From: Melissa Rassack
Sent: Thursday, 5 November 2020 1:14 PM
To: David Schwebel
Cc: William Hodgkinson; Alex Rudd; David Burge; Alejandro Trevino
Subject: RE: Request for input into SEARs - GPT Industrial Estate SSD-10272349
Attachments: 20201030 - UD Comments - Stage 1 Industrial Estate SSD.pptx

The Department has received the request for Secretary's Environmental Assessment Requirements (SEARs) for the GPT Industrial Estate (SSD-10272349).

Section A | Typical Riparian Cross Section 1:200

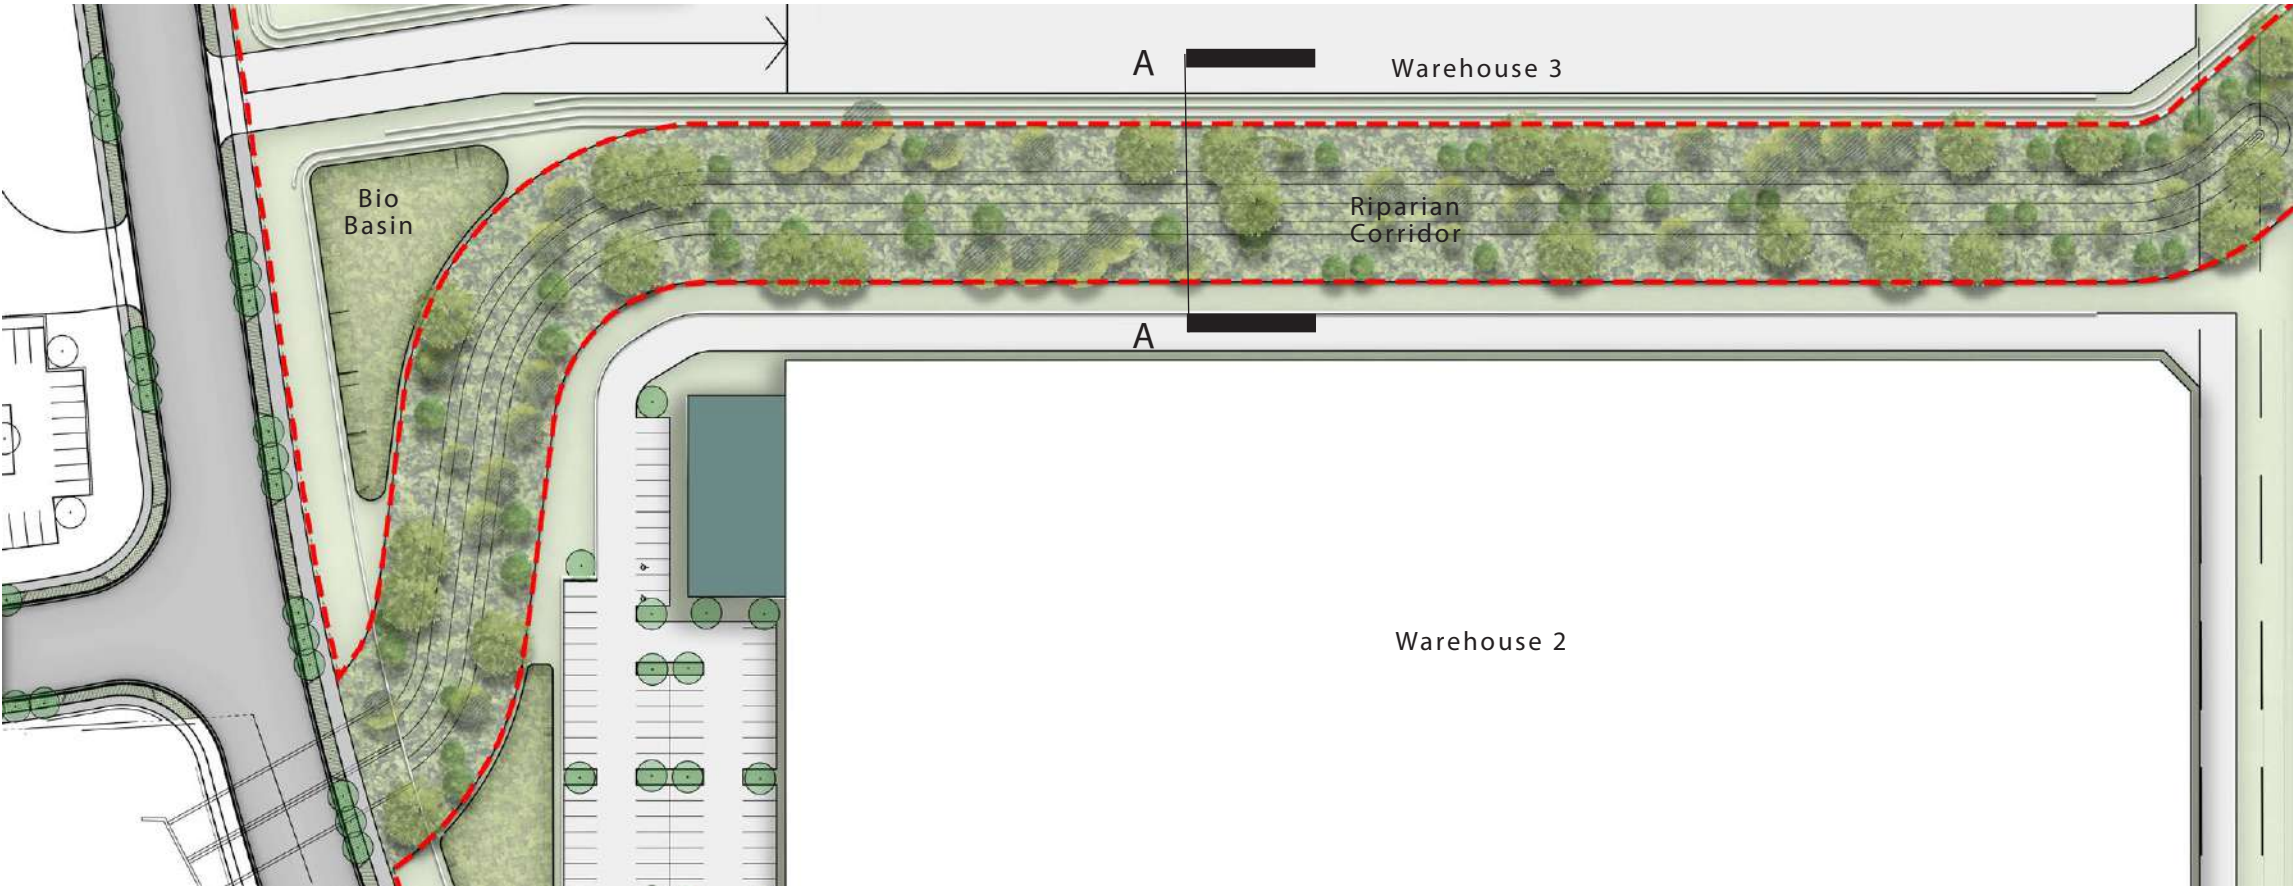
- In line with the previous DPIE advice, the riparian corridor should be designed (width and vegetation) to ensure there is sufficient area provided to support the requirements of the local ecosystem. A riparian corridor of 40 metres width should be provided and designed in accordance with the principles of the Water Management Act.

- The design treatment of the interface between industrial development and the E2 corridor is important. The design and location of hardstand areas need to avoid negative impacts on the riparian corridor including addressing noise and vibrations from vehicle movements, stormwater runoff and spillage of pollutants.

E2 CORRIDOR ALIGNMENT PLAN
SCALE 1:500

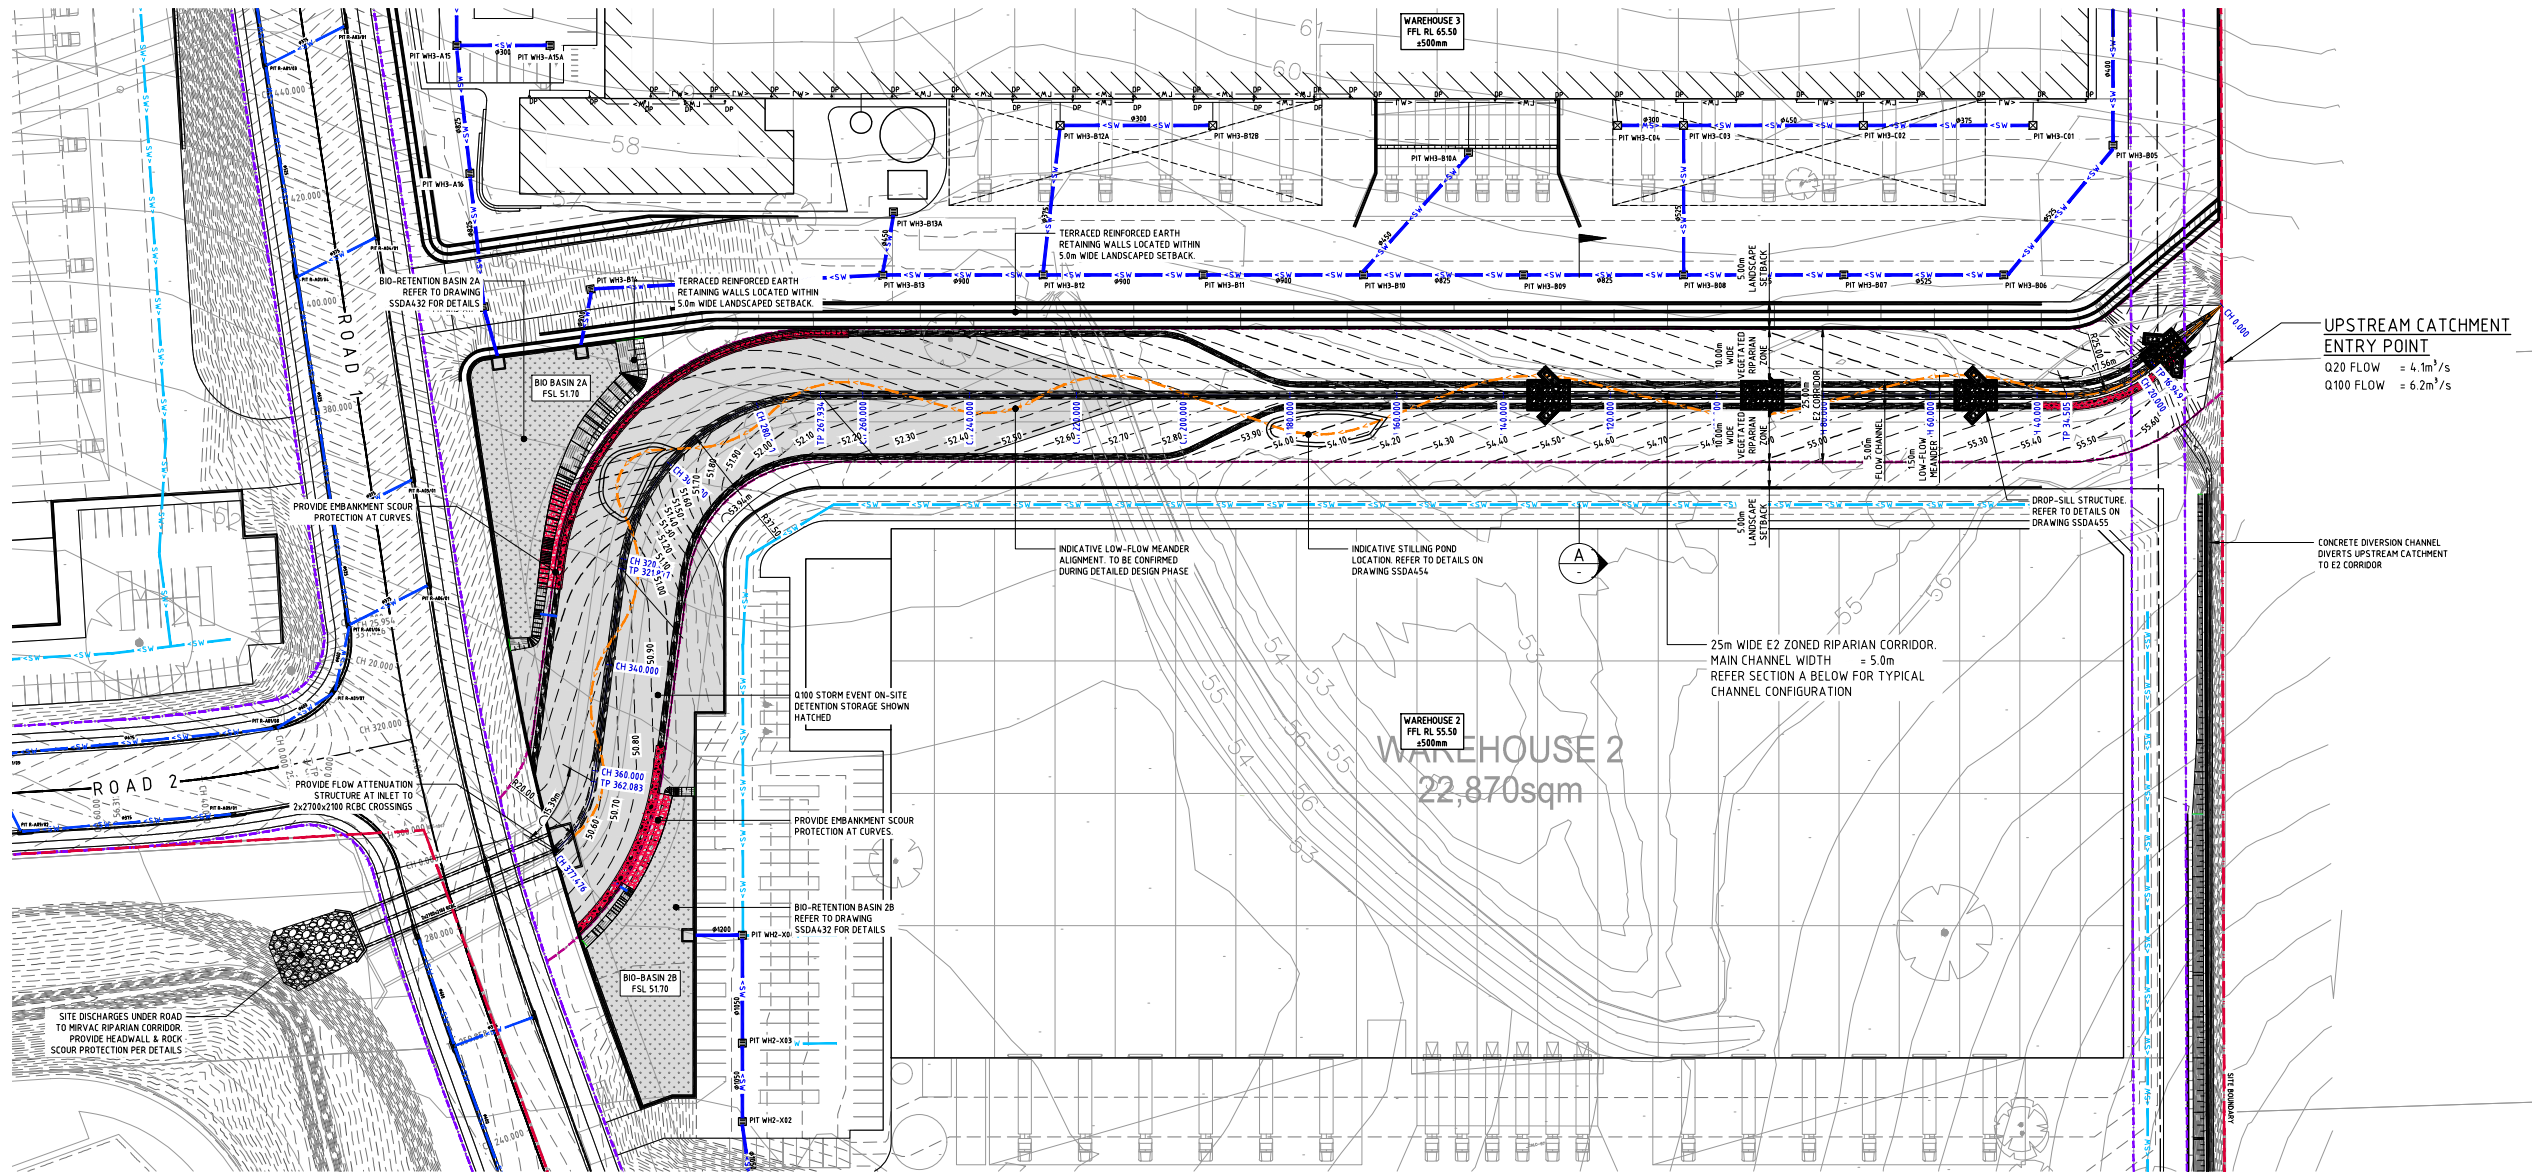
- The SSD will need to address:
 - the E2 Environmental Conservation zoning through the site. There is an important ecological/riparian corridor connecting Wianamatta-South Creek and Ropes Creek that runs through the site. NRAR should be consulted on design of this corridor.

- Demonstration that the proposed geometry changes to the riparian corridor will address adequate flow of the watercourse. A softer geometry angle may be required to improve this issue.

- Riparian corridor alignment and its connections to adjoining properties. It is noted that the applicant is seeking to relocate the zoned E2 area. This will only be considered if the above matters are satisfied and NRAR and the Department's Resilient Planning team agree to the approach.
